**Consultation Response from Alan Smith,
KC Waste Strategy (Refuse & Recycling)**

2024/92848 Marsh Carpets, 82-84, Westbourne Road, Marsh, Huddersfield, HD1 4LF

Alterations to convert first floor to 2 dwellings; sub-division of one ground floor retail unit to three retail units (use class Ea); installation of new shop fronts to south and east elevations and construction of external staircase to northern elevation including associated works

Responding Ref: WPS 25 048

Drawing
Proposed Floor Plans

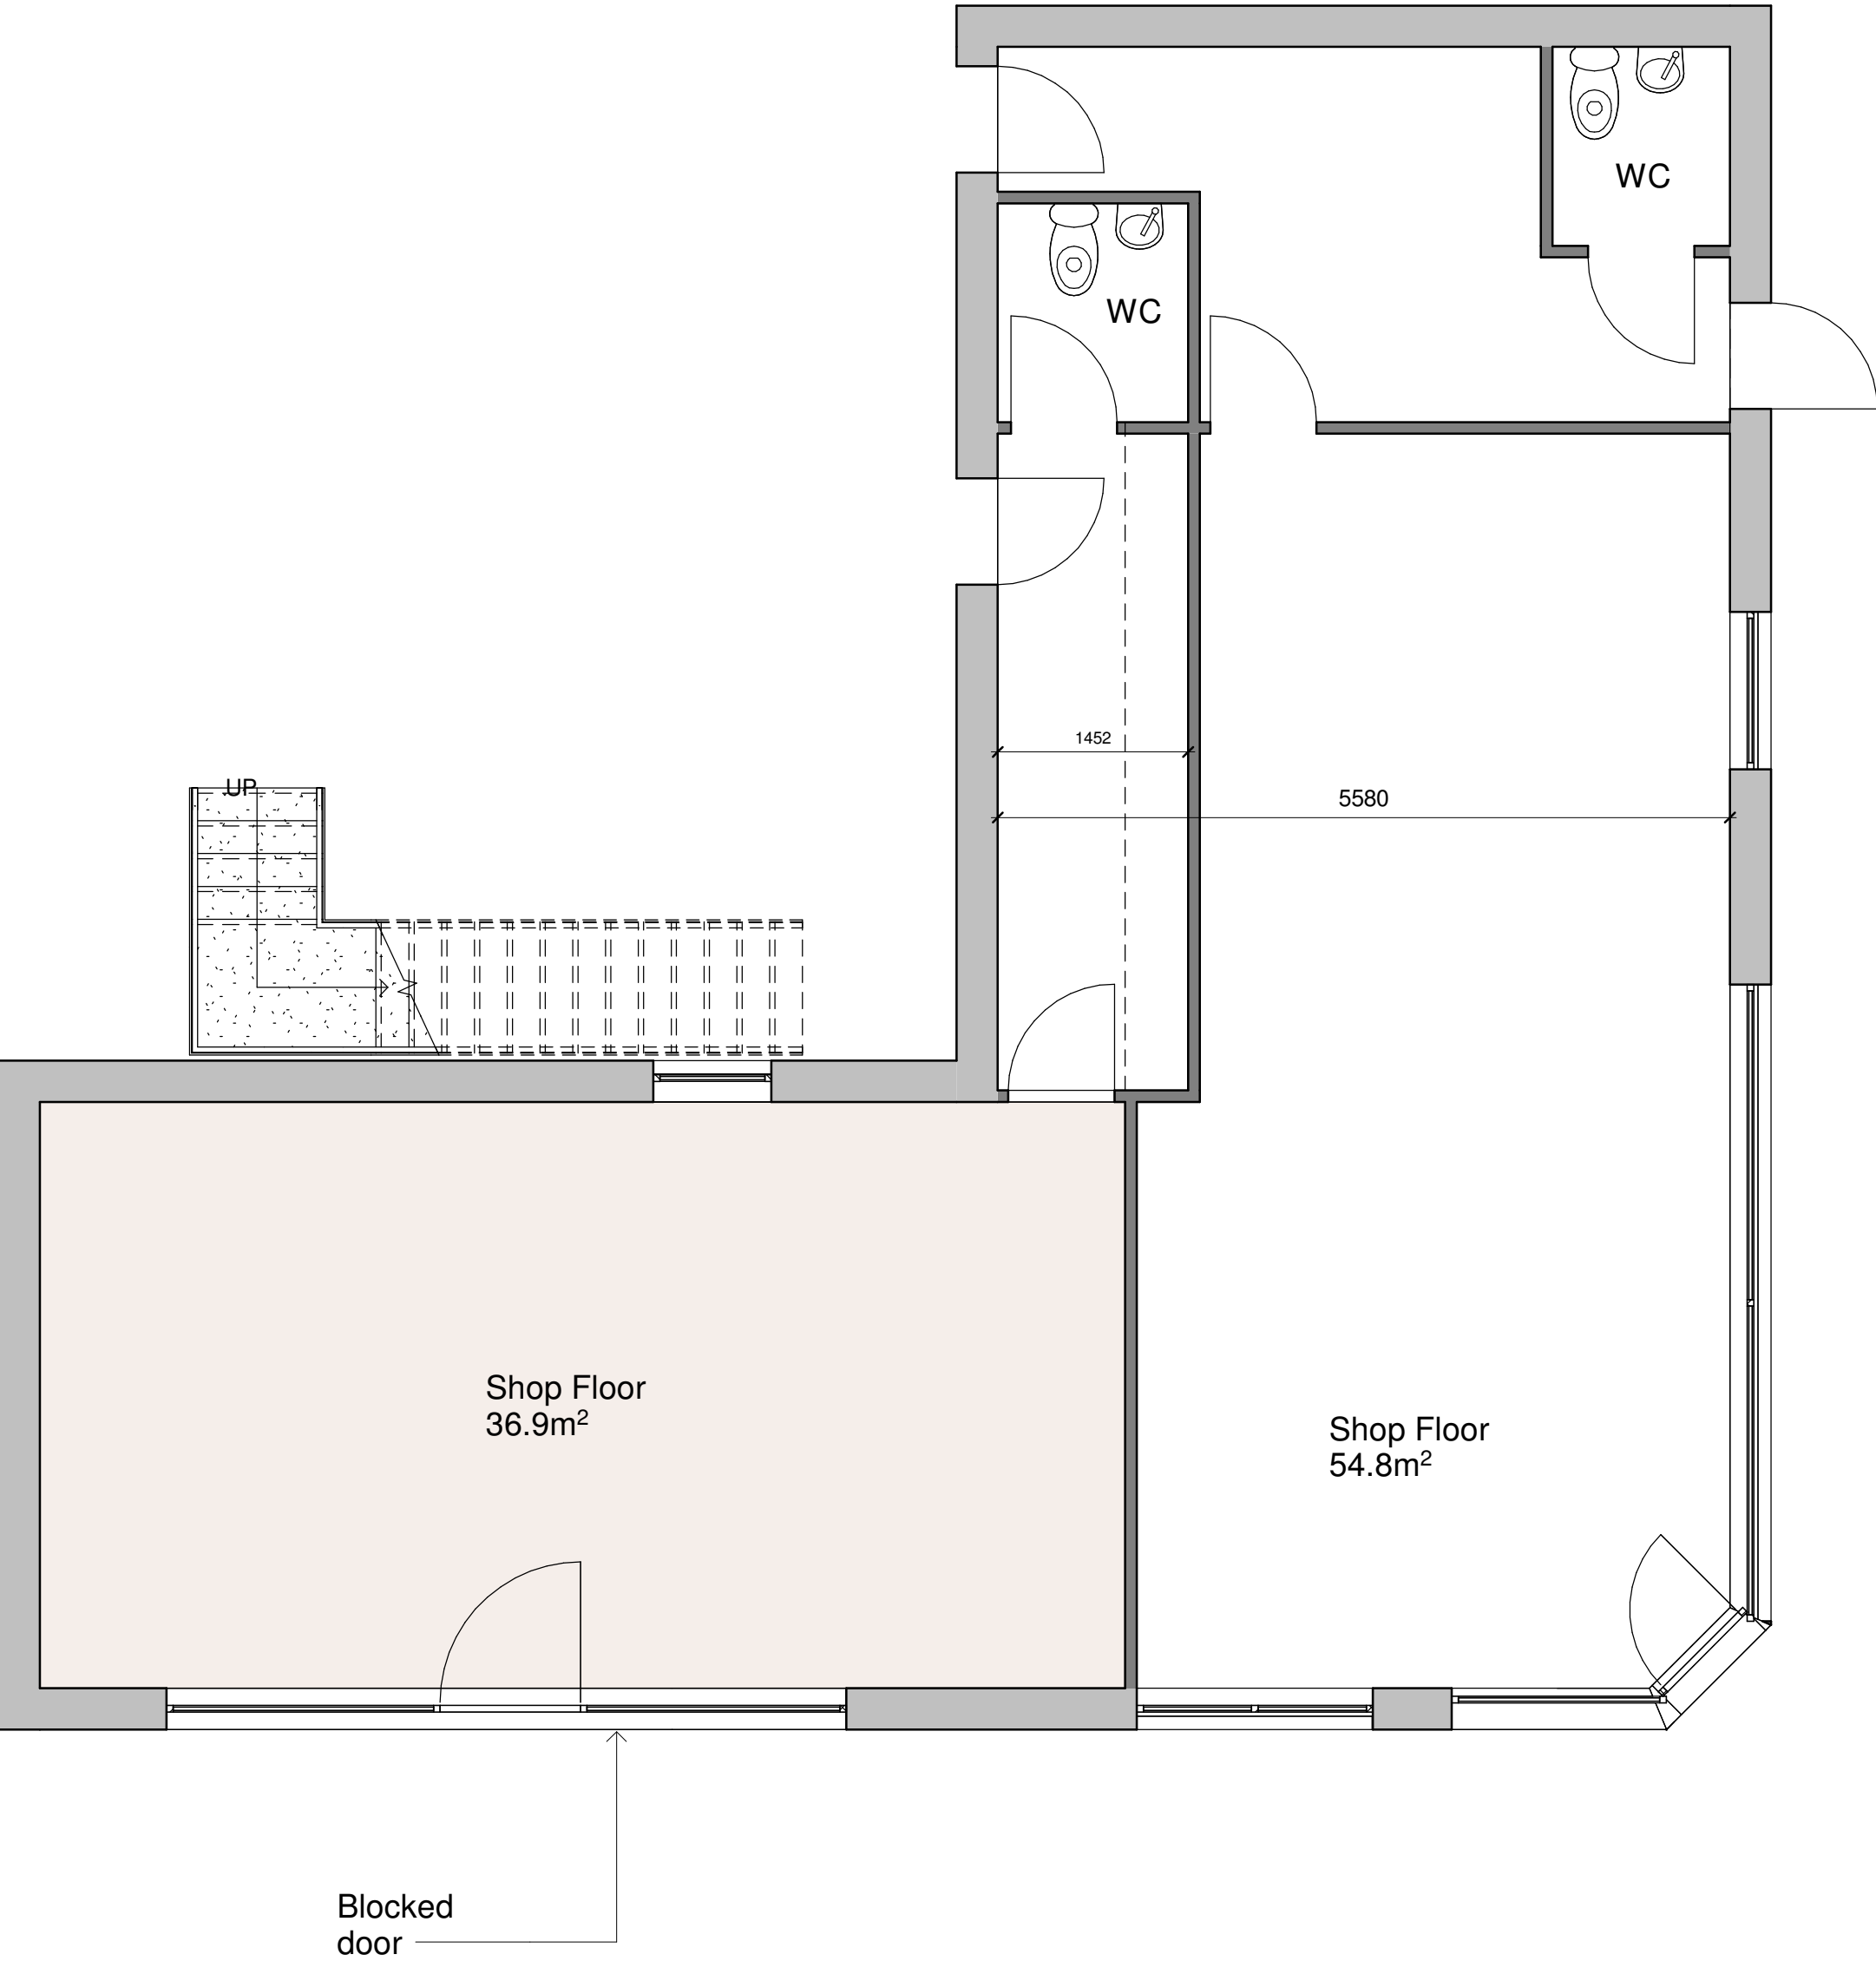
The drawing shows that 1 x 1,100L bin will be used for the commercial properties.

- **Bin space dimensions:**
 - floor space required is 1,575mm x 1,1900mm per bin
- **Bin storage location:**
 - Must not obstruct highways or driveways
 - No gradients steeper than 1:12 or steps
 - Located at least 4m away from fire exits, doors and windows
 - Not located underneath fire escapes
 - Where the container cannot be located 4m away from a property then it is necessary that the adjacent structure is fire resistant, which has a resistance to fire of 30 minutes

Prior to commencement the developer must submit for approval details for bin storage, screening, BCPs, and RCV access. The approved details shall be provided before first occupation and shall be so retained thereafter.
